App No: CM/21/19/PL

Address: Land adjacent to Scyld Horsemere Green Lane Climping BN17 5QZ

Proposal: Construction of 9 no. dwellings, access, landscaping and associated works.

Drawing Title
Tree Retention and Protection Plan
Sheet 01

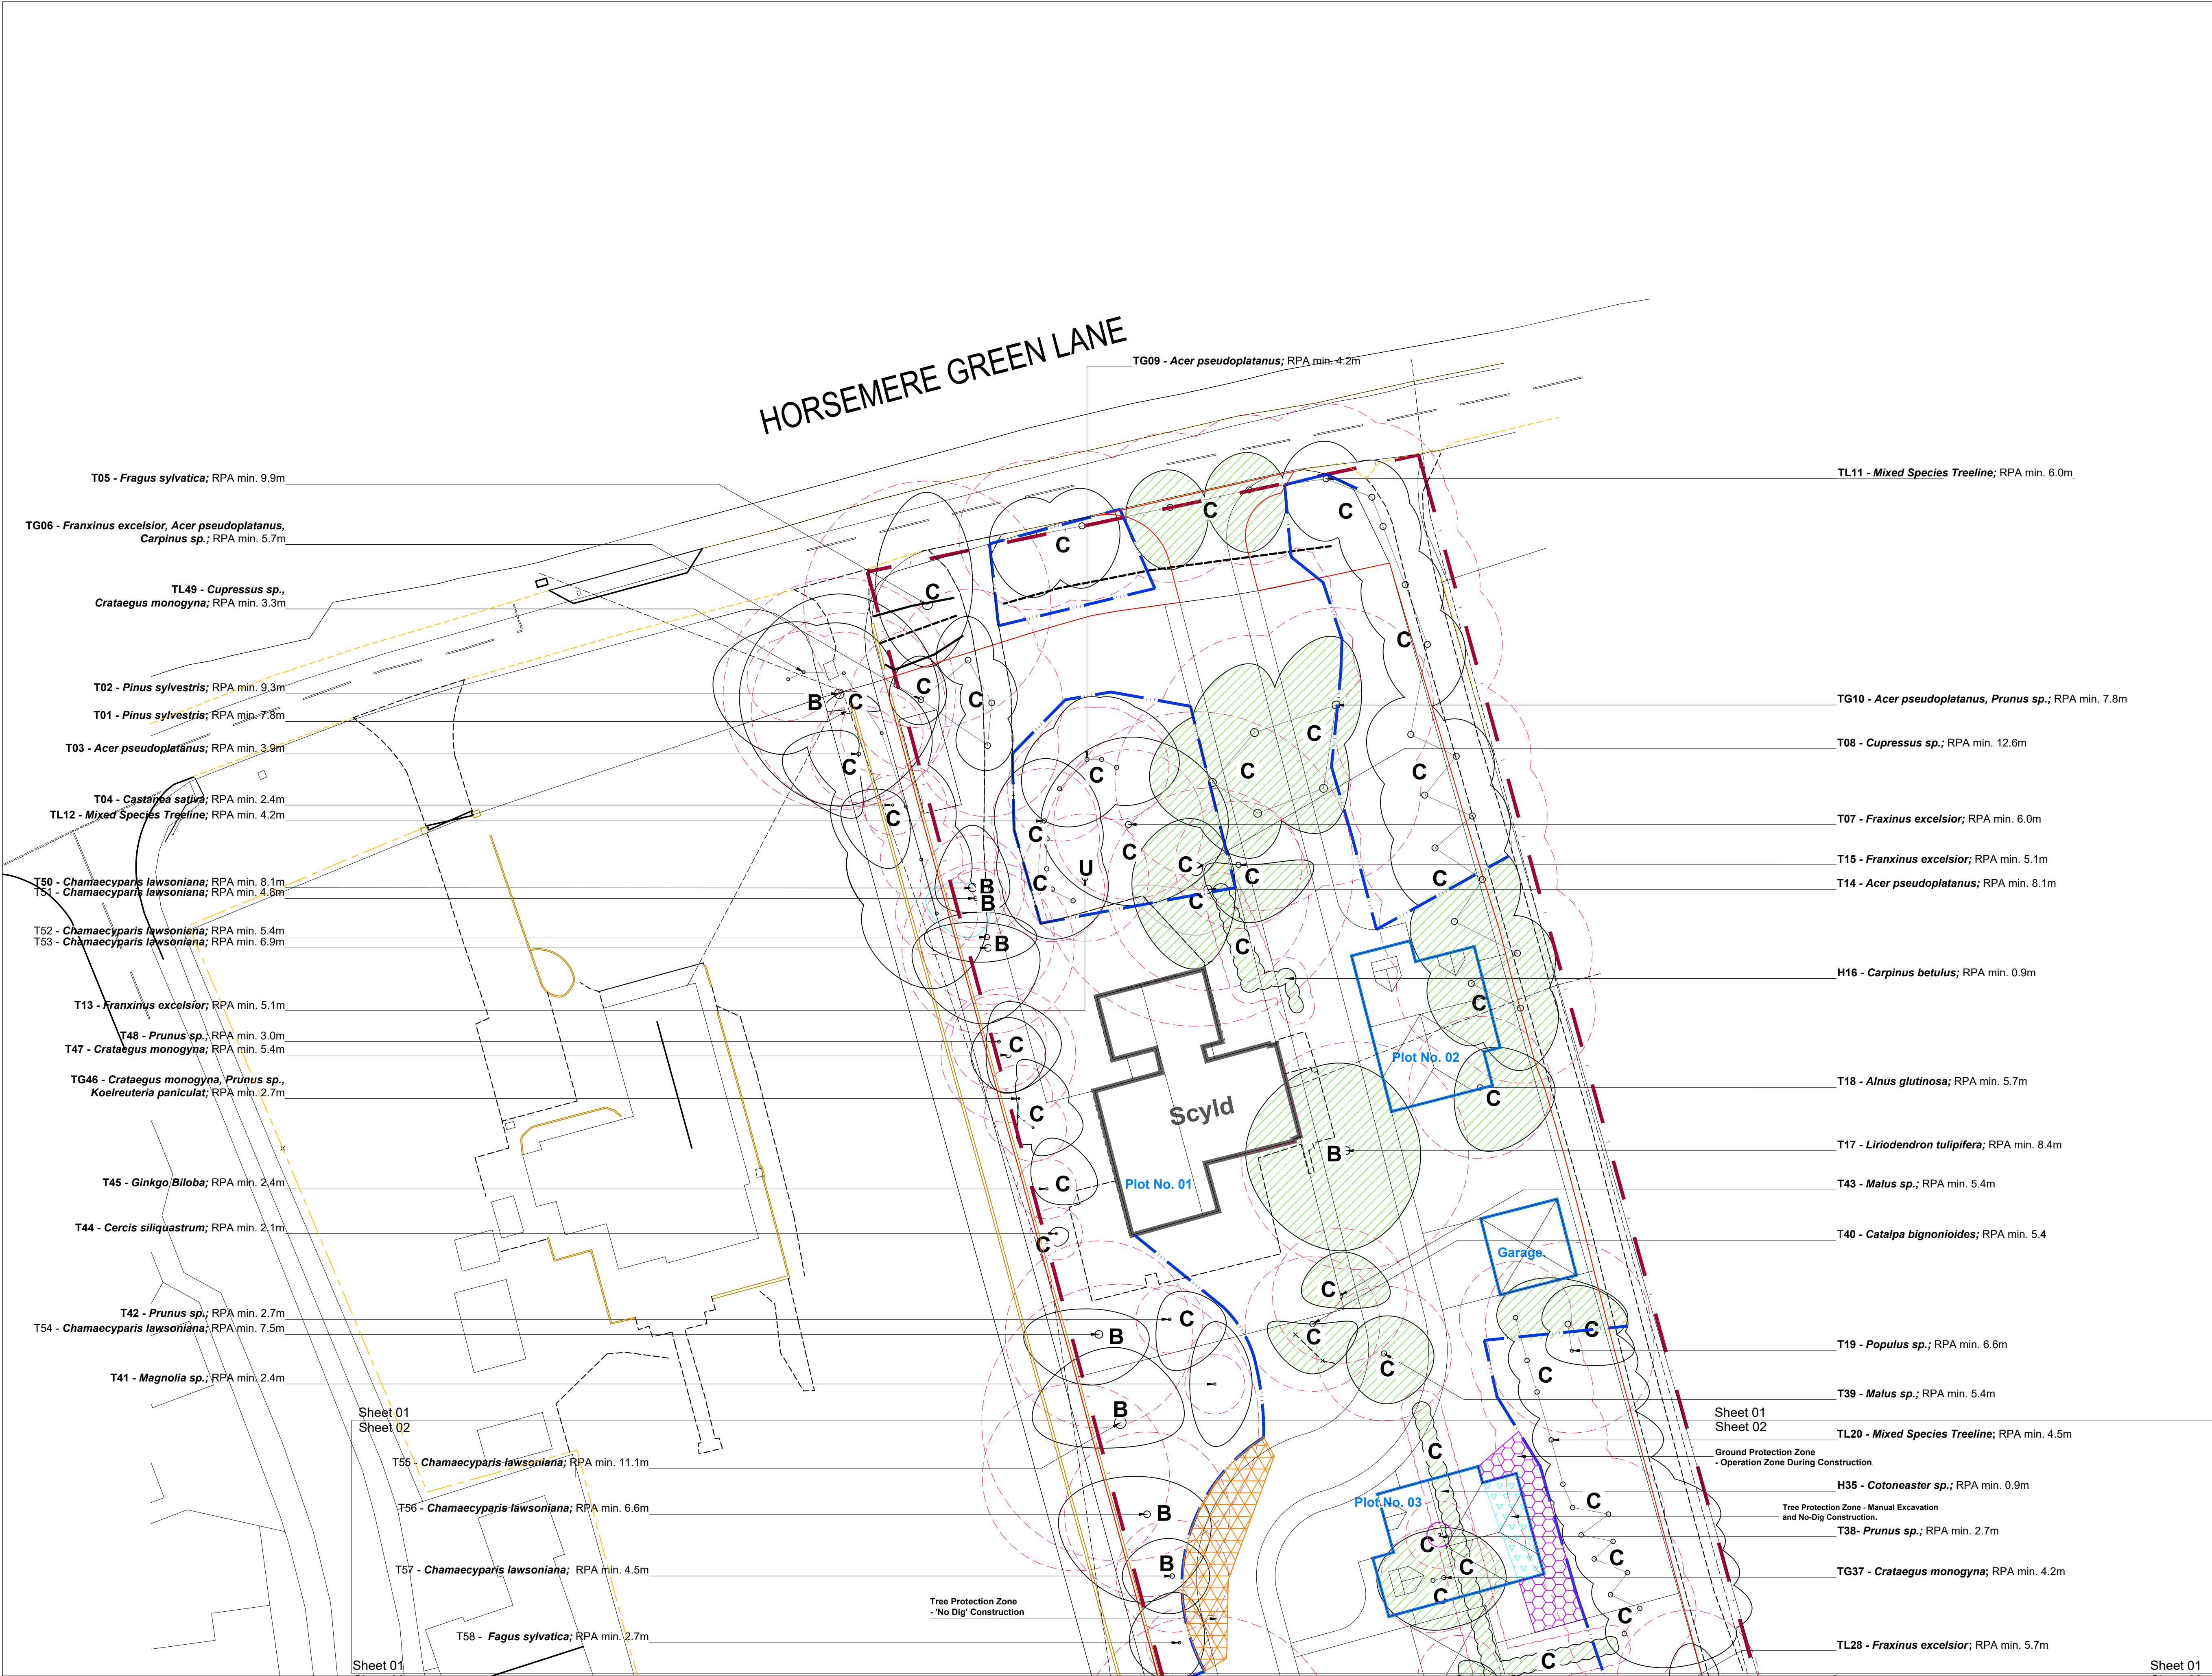
The hedgerows on site are used by protected species for commuting and foraging and will need to be retained and enhanced. This will include having a buffer strip around the hedgerows (5m) and during construction fencing should be used to ensure this area is undisturbed. Any gaps should also be filled in using native hedge species to improve connectivity. Conditions should be used to ensure this.
